**Subject:** Rezoning Petition Review

**Date of Review:** December 22, 2021 (*Revised January 24, 2022*)

**Rezoning Petition #:** 21-195

**Location of Property:** Approximately 60.65 acres located on the north side of W Arrowood Rd, east of I-485 and south of Shopton Rd.

PROPOSED BUFFER & LANDSCAPE AREAS

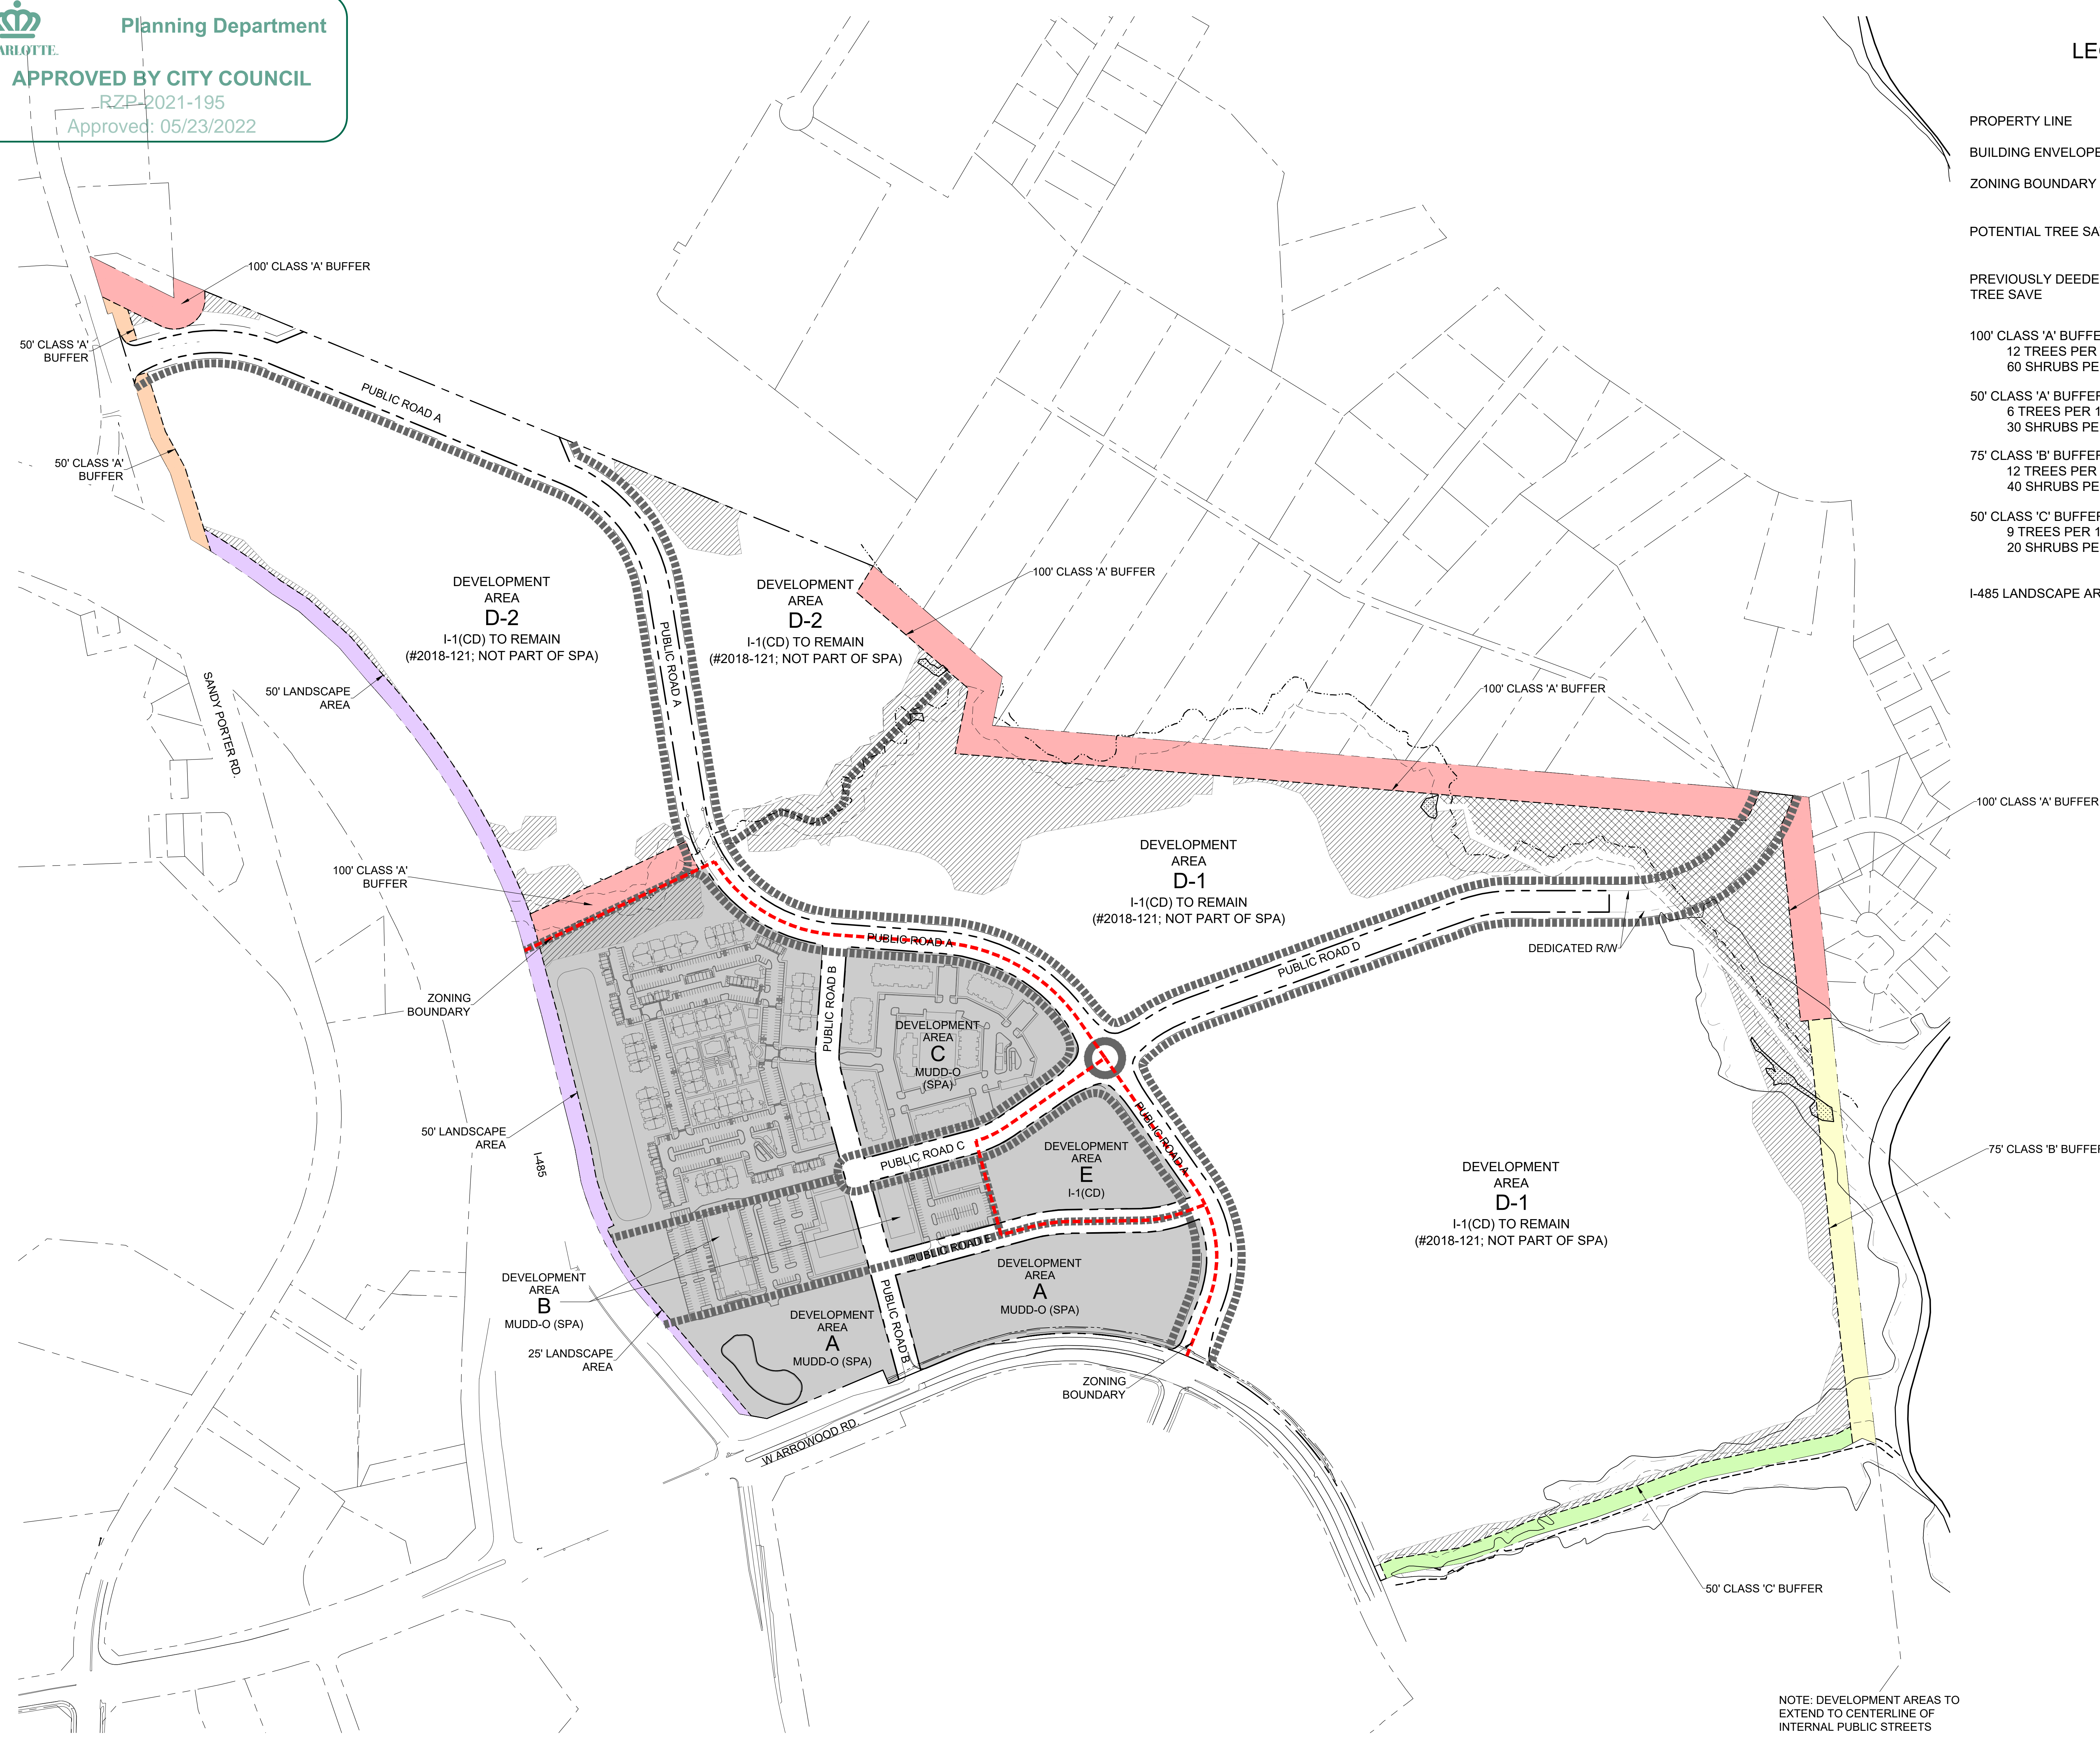
**Concerning Storm Water:** City of Charlotte GIS indicates a 30-ft PCSO Buffer on the site near/through Development Areas A and C. Please show all buffers and include the following note under Environmental Features: *“Development within any SWIM/PCSO Buffer shall be coordinated with and subject to approval by Charlotte-Mecklenburg Storm Water Services and mitigated if required by City ordinance. Petitioner acknowledges intermittent/perennial stream delineation reports are subject to review and approval upon submission of development plans for permitting and are not approved with rezoning decisions.”*
